Please can the below be uploaded as planning correspondence for AL/23/20/HH

I am the case officer on an application at 26 Belle Meade Close in which Miss Hole is the agent on.

Proposed Ground Floor Plan

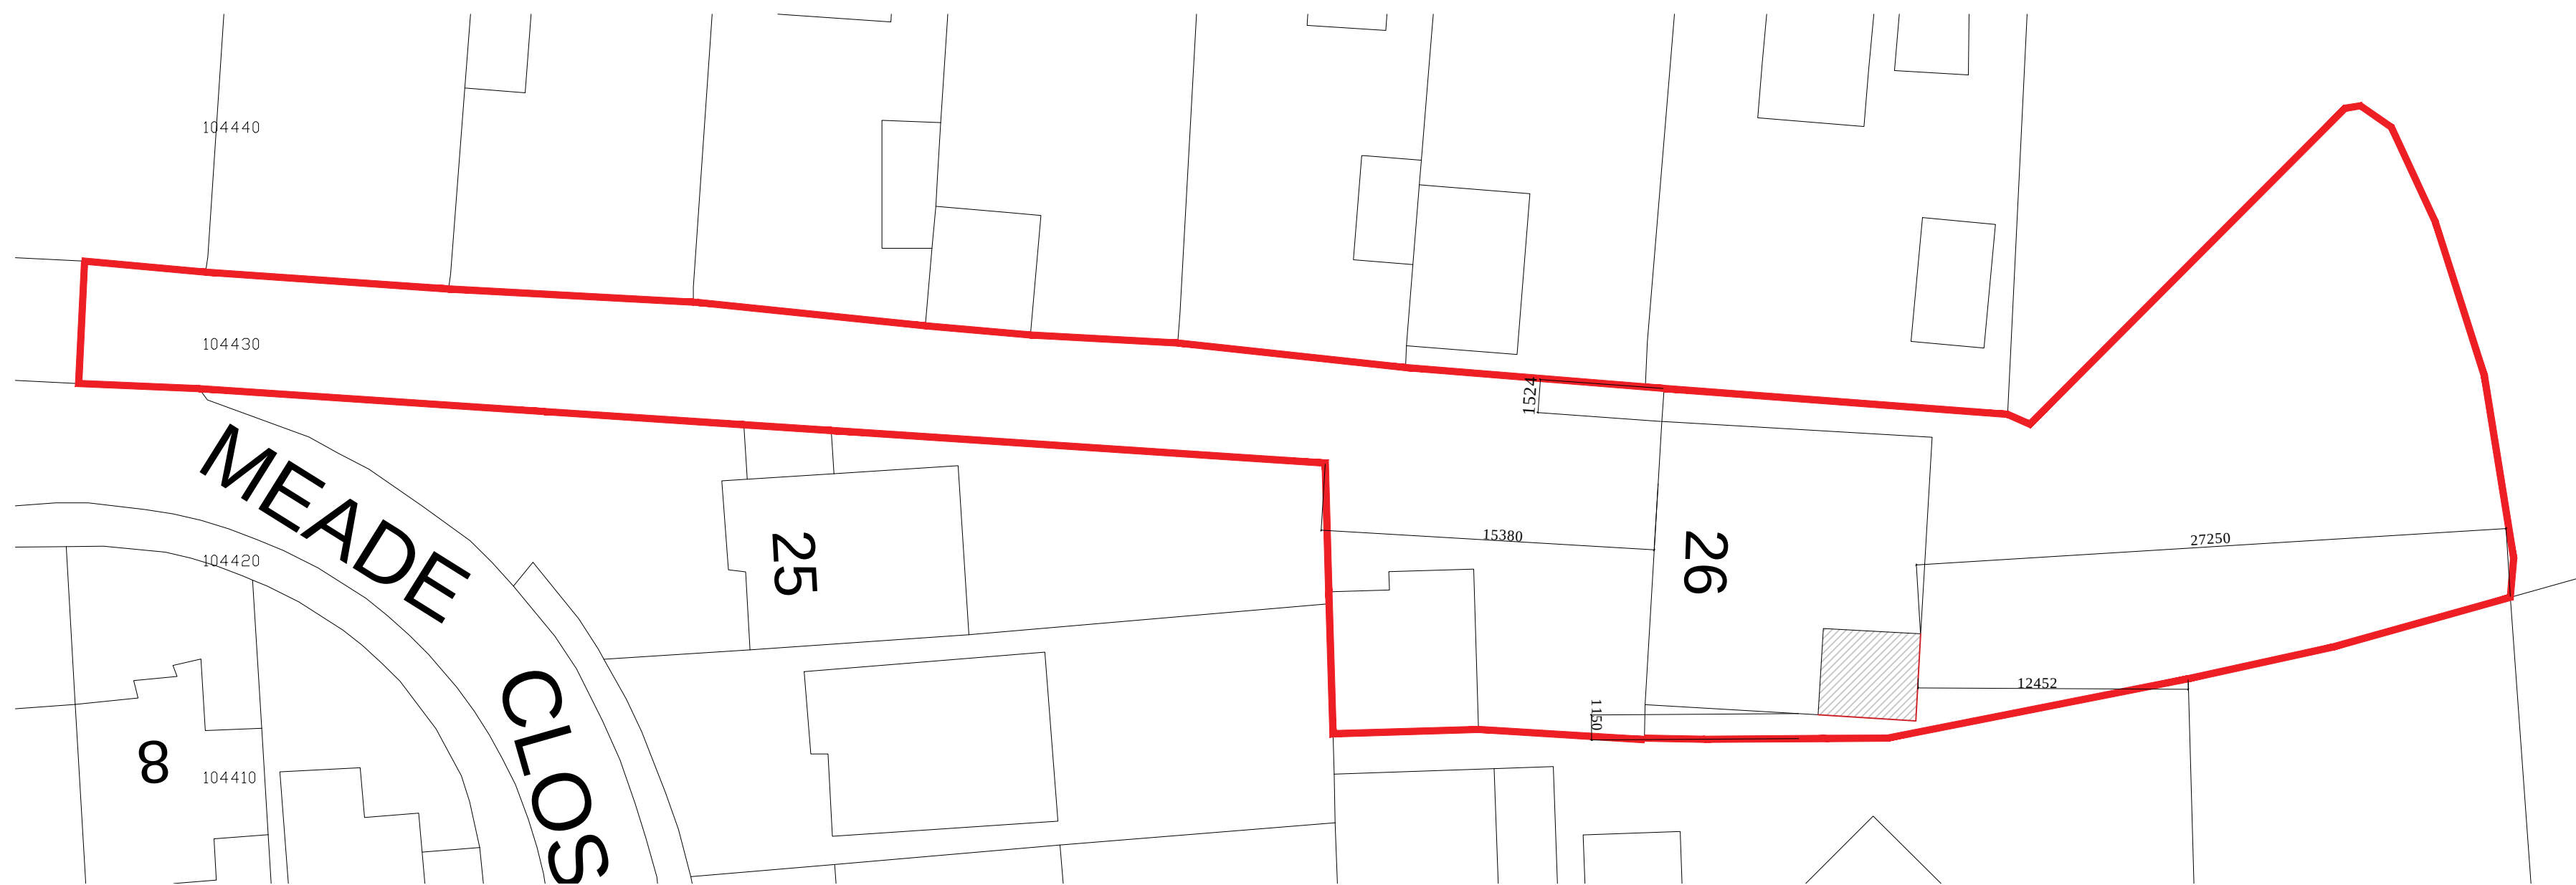
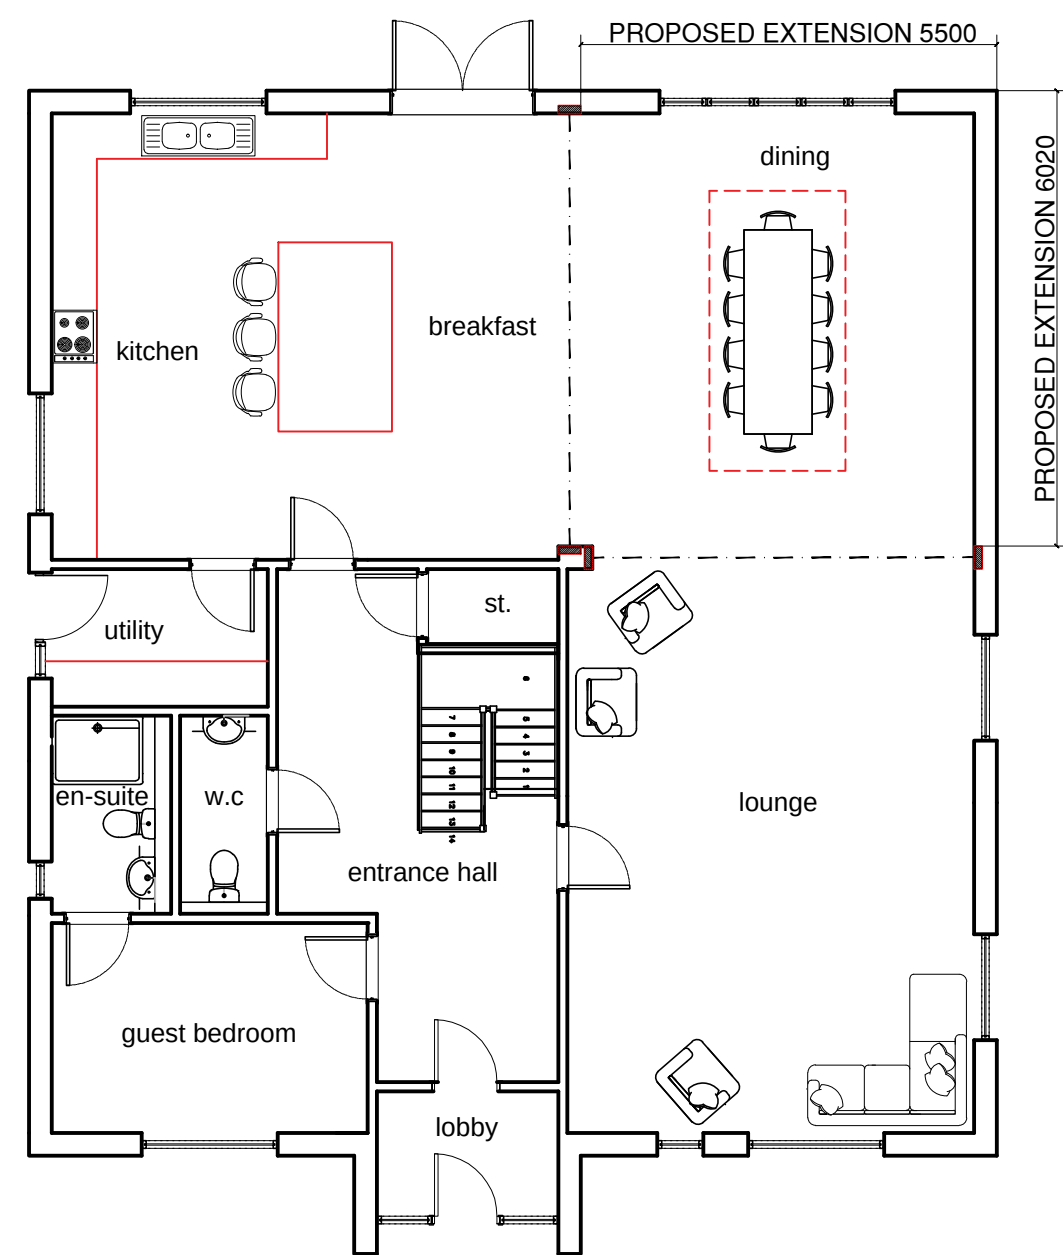
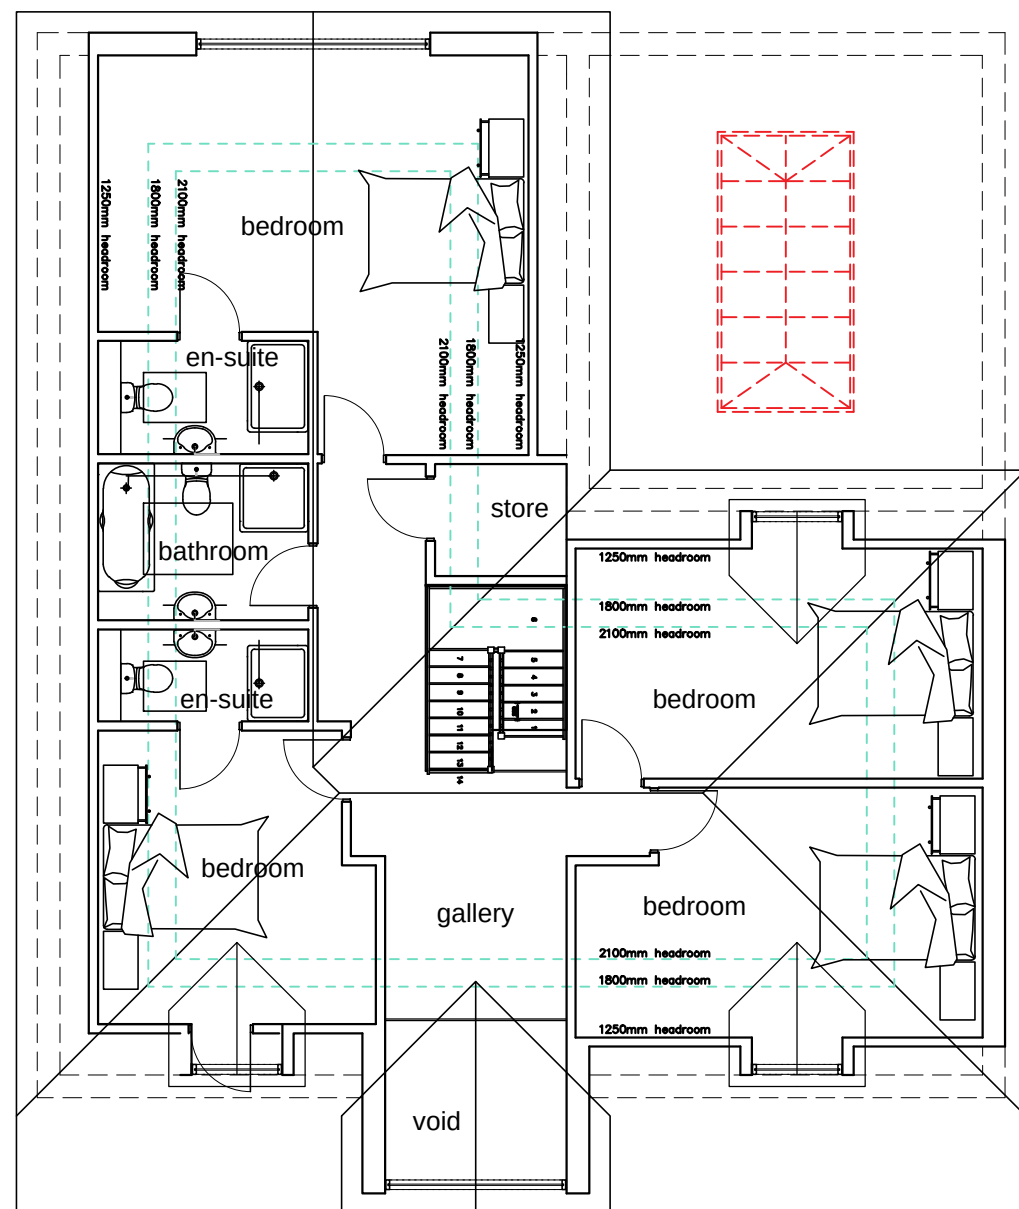
I have also just measured the proposed internal floor space and believe it is likely over 100sqm and therefore CIL liable. Are you able to send a revised CIL form 1 over. You may be able to claim for relief. I attach the form and guidance.

Proposed Rear Elevation

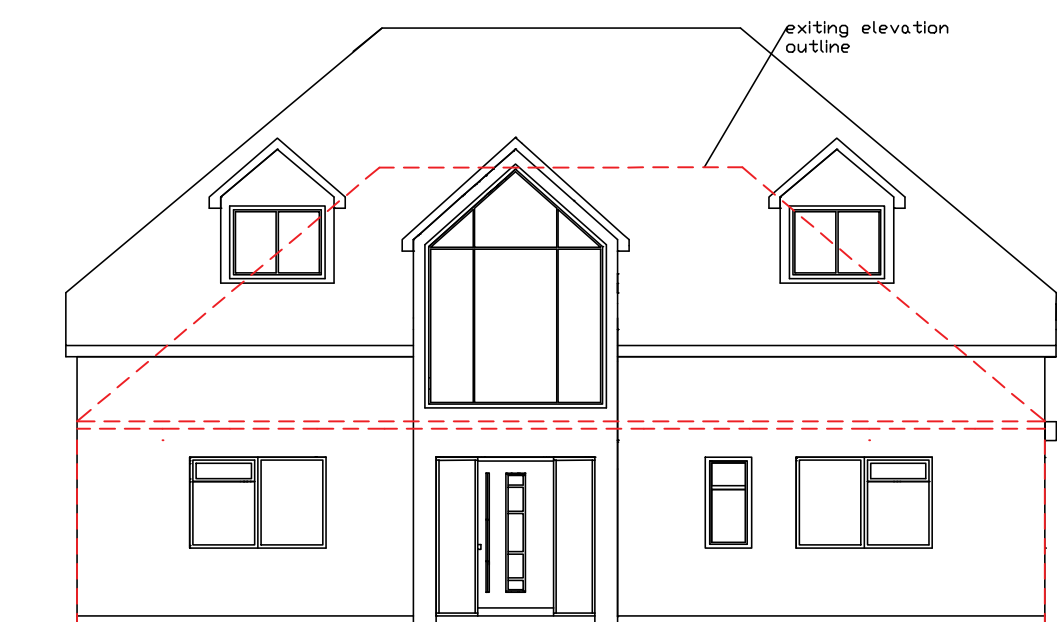
The only slight concern I have is the new rear dormer towards the southern side facing east which will likely provide some overlooking towards reed cottage, however you could likely put a dormer there now under PD which would provide the same, so probably couldn't argue the impact is significant.
